From: Simon Davis
Sent: 22 March 2018 10:03
To: Planning Scanning
Subject: FW: P/1/18/DOC - Application for approval of details reserved by conditions imposed under planning permission P/125/14/PL - Land @ 251 Pagham Road

From: Simon Davis
Sent: 22 March 2018 10:03
To: 'Liz Rogers'; Fiona Fitzgerald
Subject: P/1/18/DOC - Application for approval of details reserved by conditions imposed under planning permission P/125/14/PL - Land @ 251 Pagham Road

drawing title	Landscape General Arrangement (East)				
drawing no.	1896-TF-00-00-DR-L-1002				P03
scale	1:250 @ A1	date	28.09.17	drawn by	AC
				checked by	AC

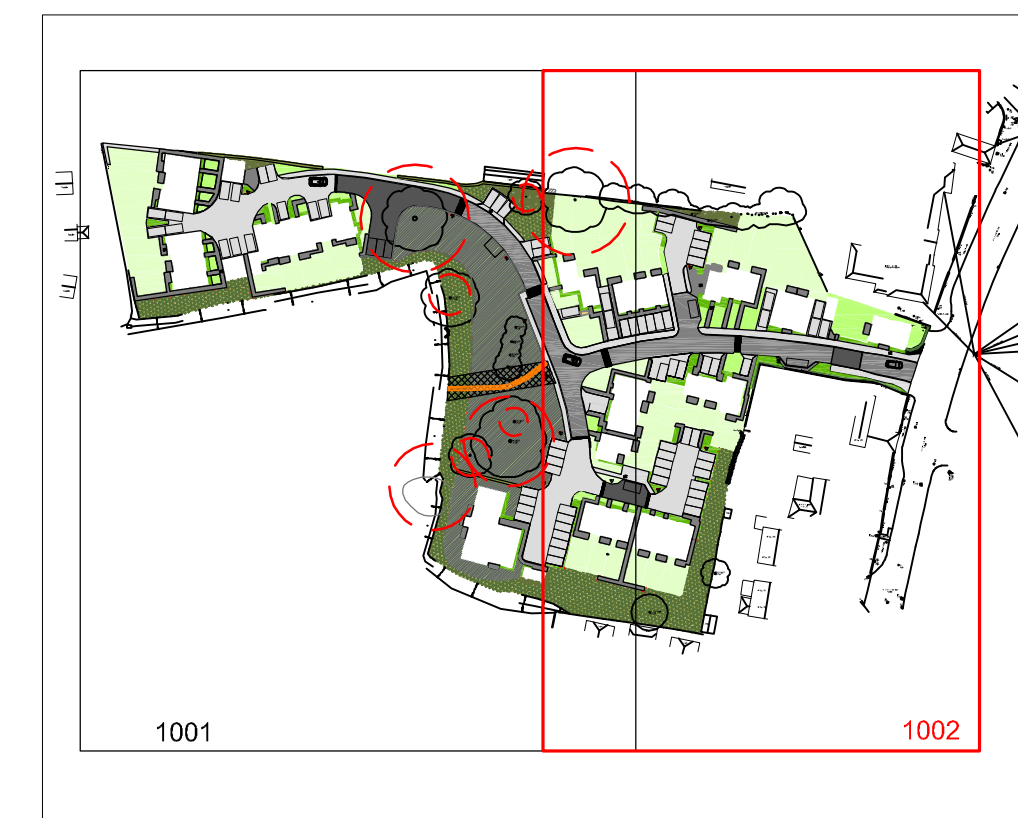
There is one condition on this application regarding lighting which I have not had any specific response from Ecology (Liz) on or any response from Environmental Health (Fiona). The condition states:

No external lighting shall be installed on the site until plans showing the type of light appliance, the height and position of fitting, illumination levels and light spillage have been submitted to and approved in writing by the Local Planning Authority. The scheme should also minimise potential impacts to any bats using the trees, hedgerows and buildings by avoiding unnecessary artificial light spill through the use of directional light sources and shielding. The lighting approved shall be installed and shall be maintained in accordance with the approved details.
